Date: 14th February 2012
To: Planning
Cc: -
From: Miriam Hill
Subject: S6/2012/0096/FP – 9 Wilkins Green Lane, Hatfield
Erection of two storey front extension

I have reviewed the proposal for the above site and refer to drawing number WGL 102-10.

DRAWING No.  
WGL 102-10

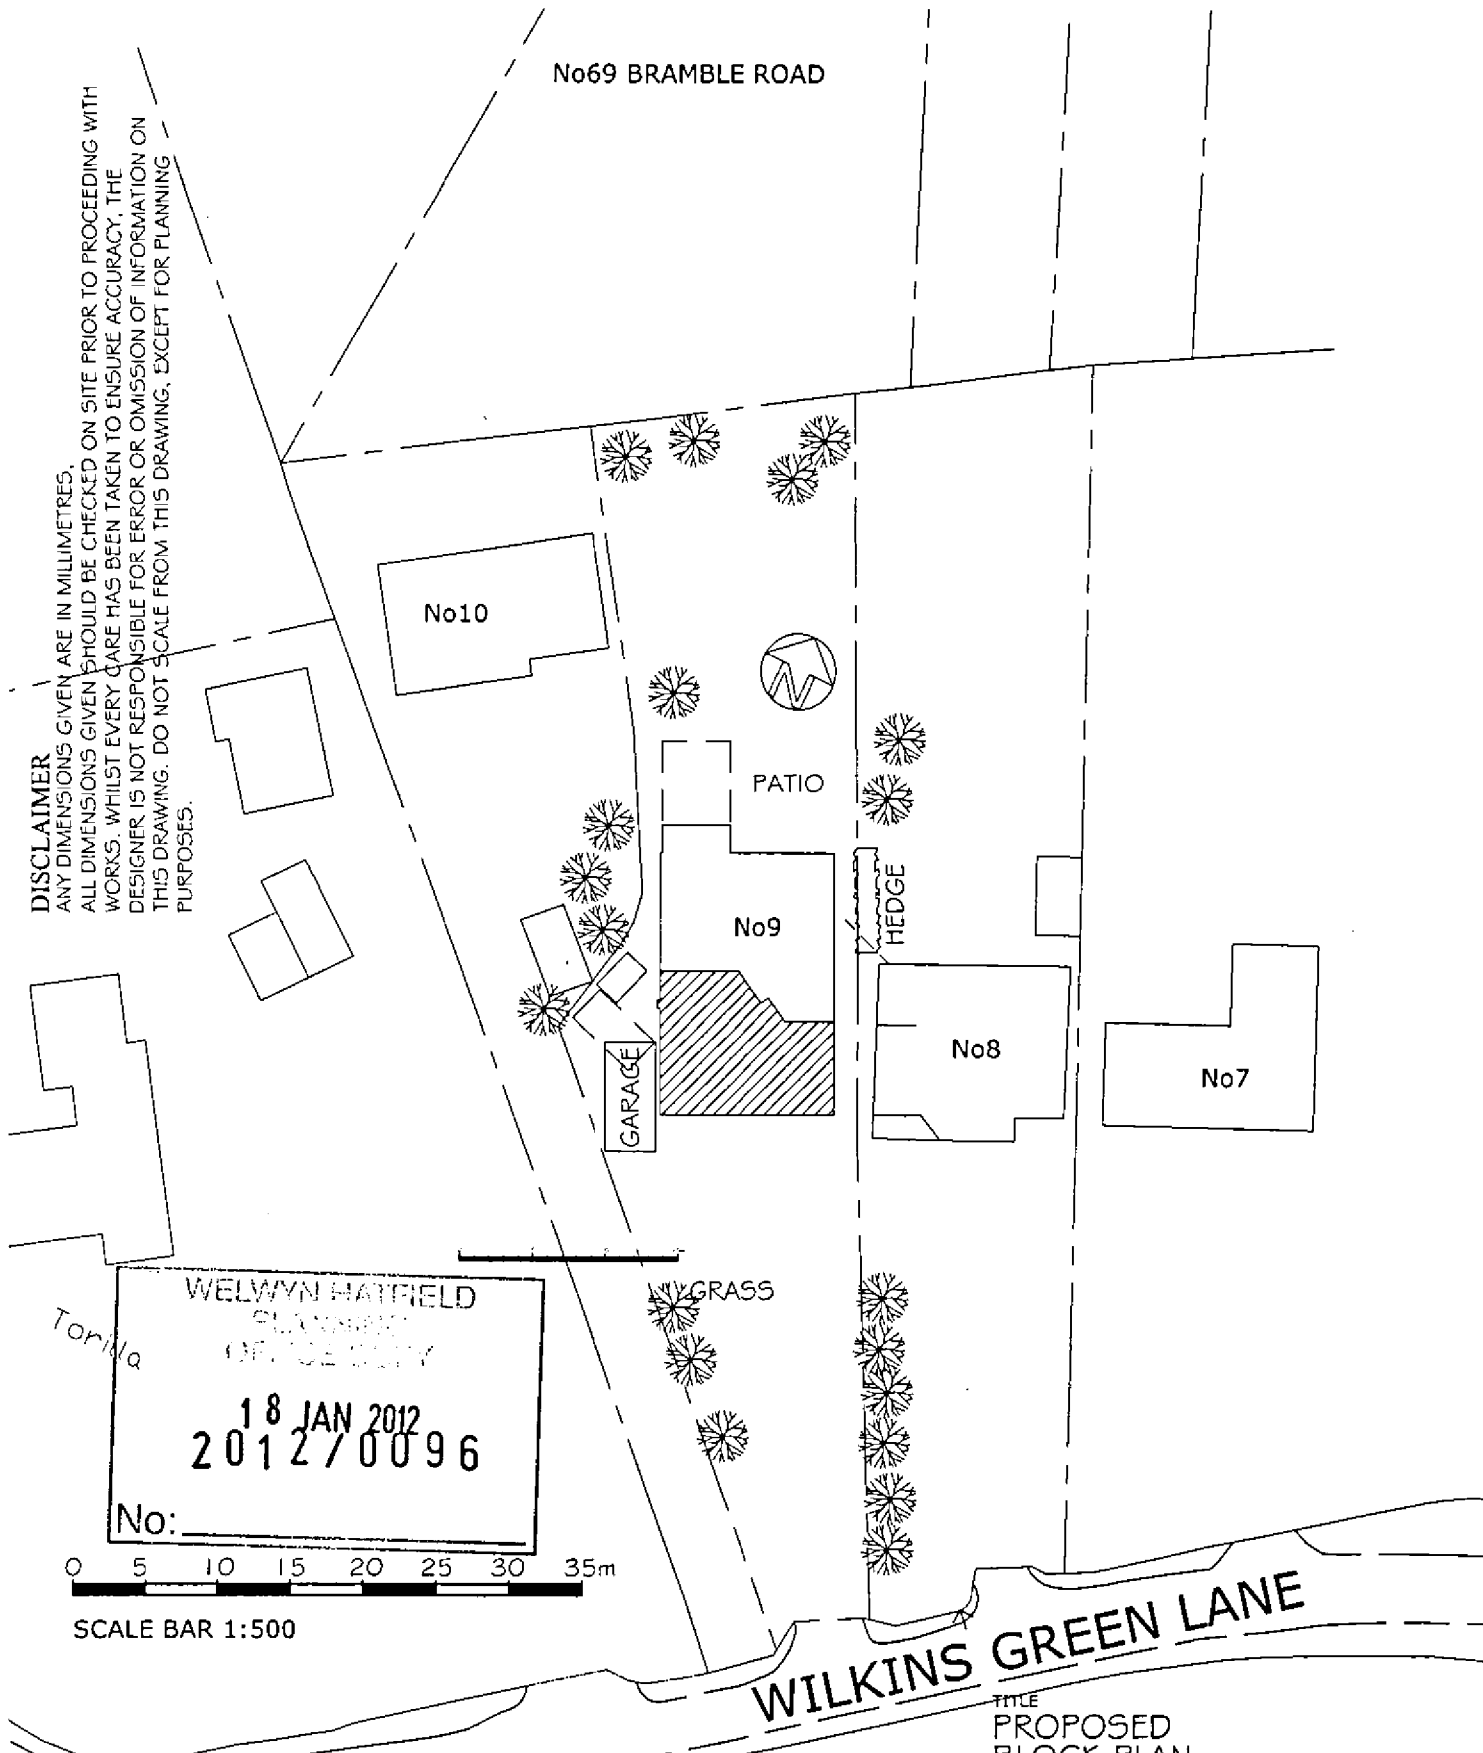
There are several trees within the front garden and adjacent to the site. Although they have some amenity value, they are not of sufficient quality to protect with a Tree Preservation Order. The applicant should bear in mind that excavation or compaction of the soil close to trees can damage the roots and/or soil and be potentially harmful. If the intention is to keep the trees for screening, privacy or as a focal point in the garden, care must be taken whilst working around them, guidance can be sort from BS5837:2005 Trees in Relation to Construction or from a arboricultural or landscape professional.
